Re: **Kendall Auto Group Auto Storage Yard - PA 23020**
IECO No. 20-1092

The project referenced above is revised in response to the review comments dated April 17, 2024. The review comments are numbered on the letter and have been addressed in *italics* as follows:

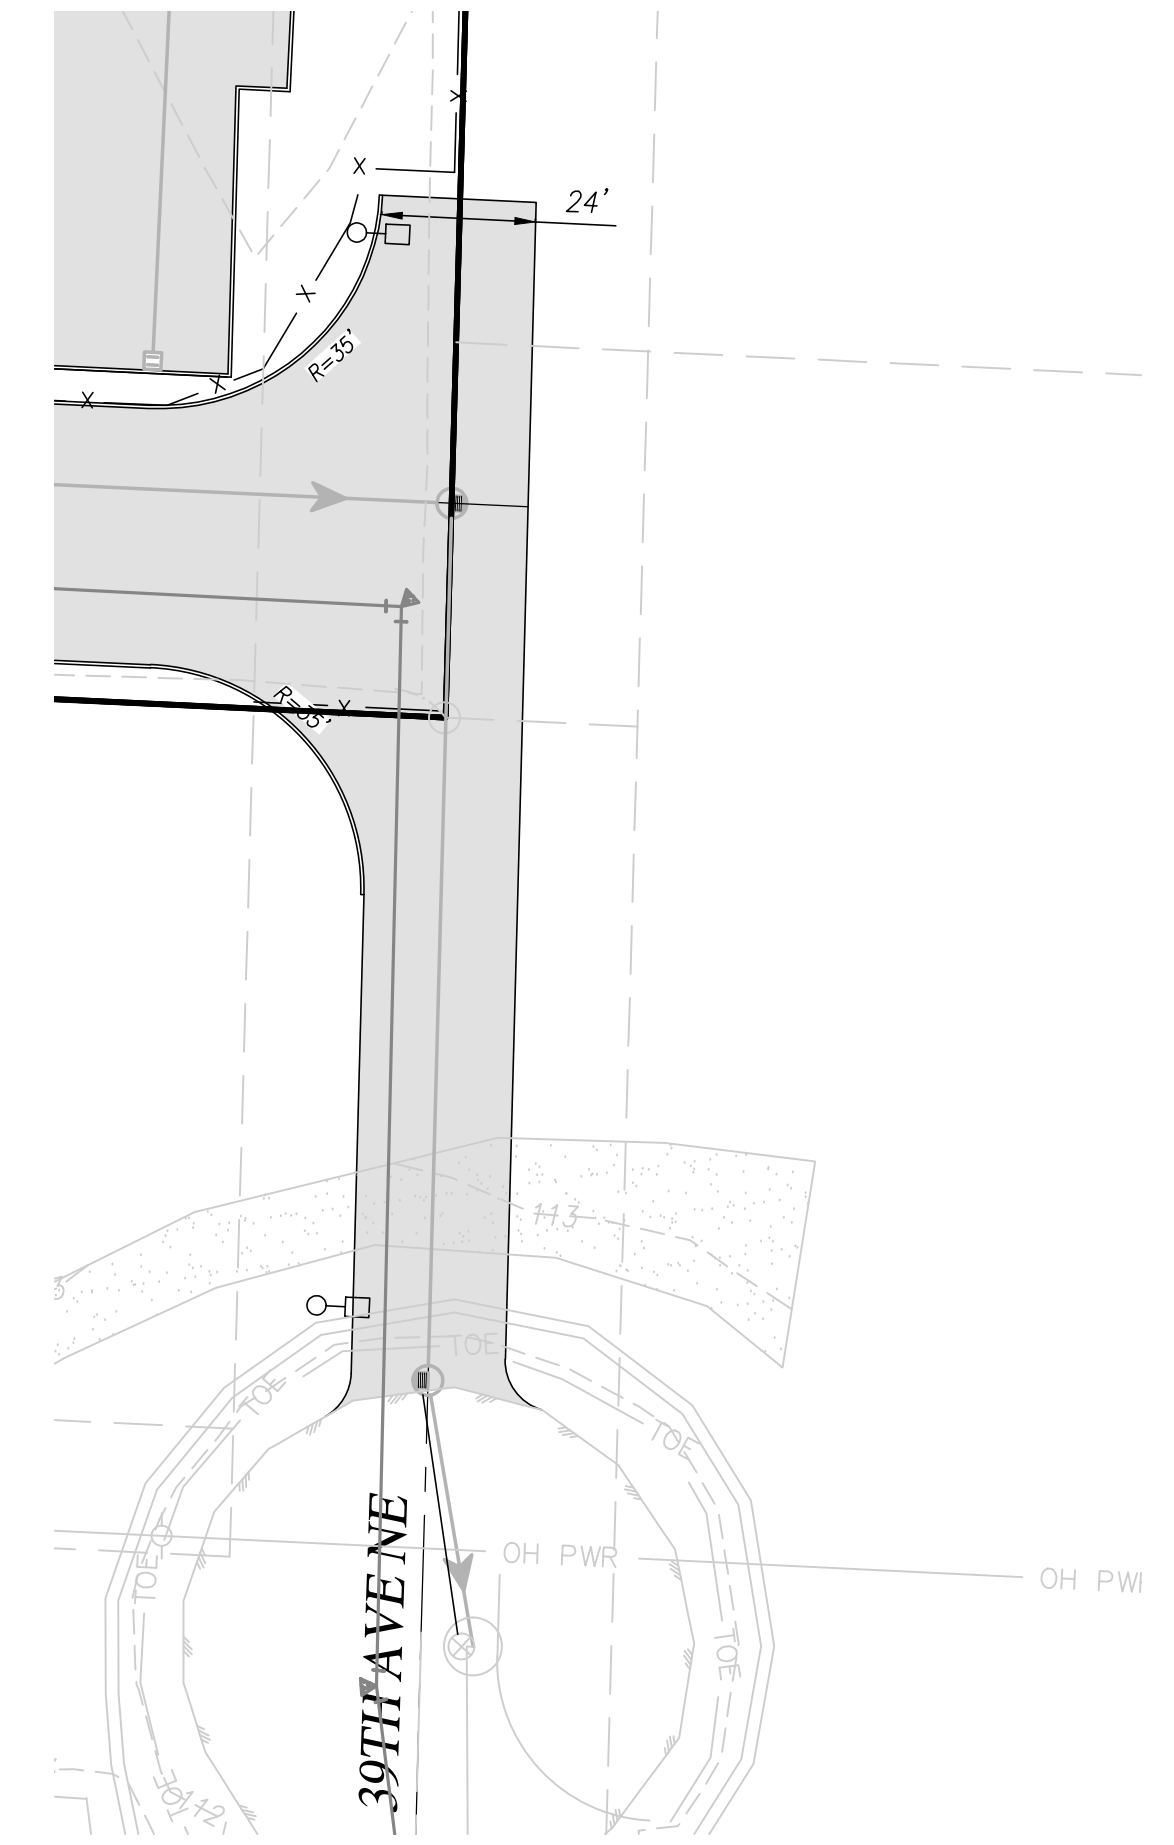
2. The site plan will need to be amended per the comments below from Kacey Simon, Civil Plan Reviewer.

Please see the new site plan for the revised layout.

HORIZONTAL CONTROL PLAN
SHEET C1.2

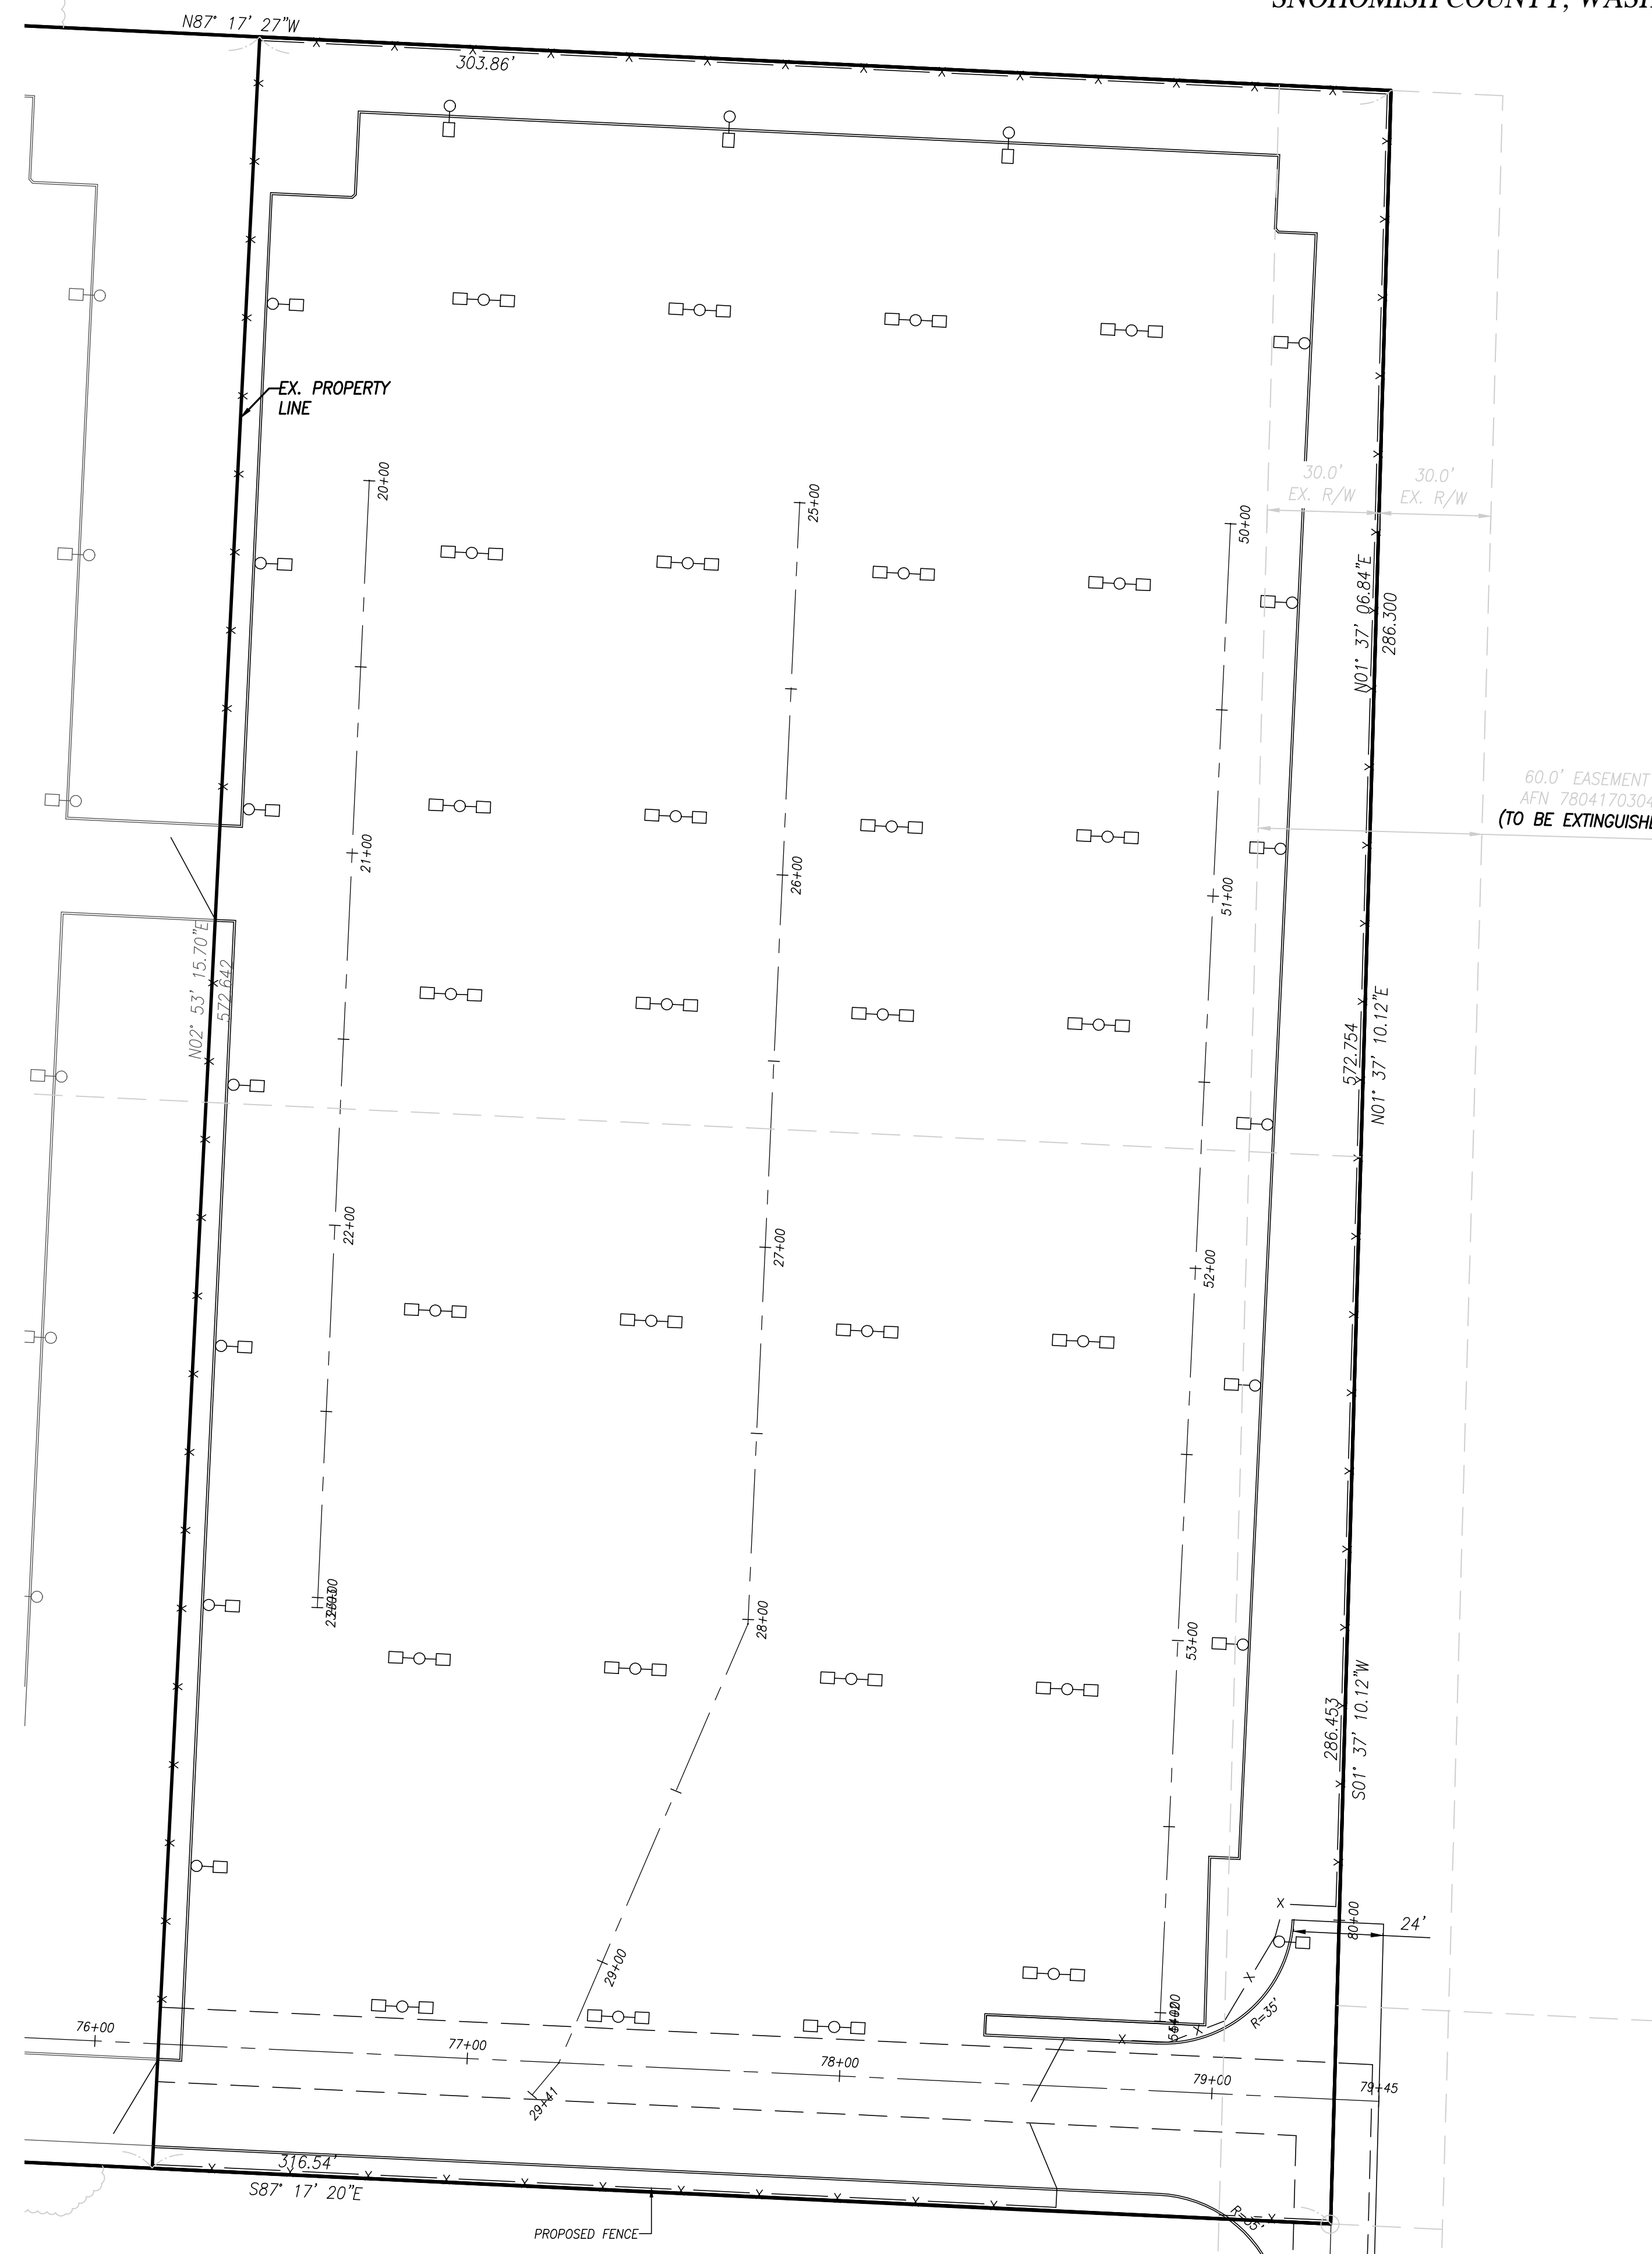
3. Access to the site may be provided via a private driveway north of the intersection of 160th Street NE and 39th Avenue NE. The private driveway shall include a hammerhead turn-around consistent with Marysville Standard Plan 3-207-004. If the site is intended to have a perimeter fence, the fence shall remain outside the limits of the required turnaround. If this parcel is redeveloped in the future, then additional improvements, including curb, gutter and sidewalk may be required.

Please see the revised plan for the hammerhead turn around.
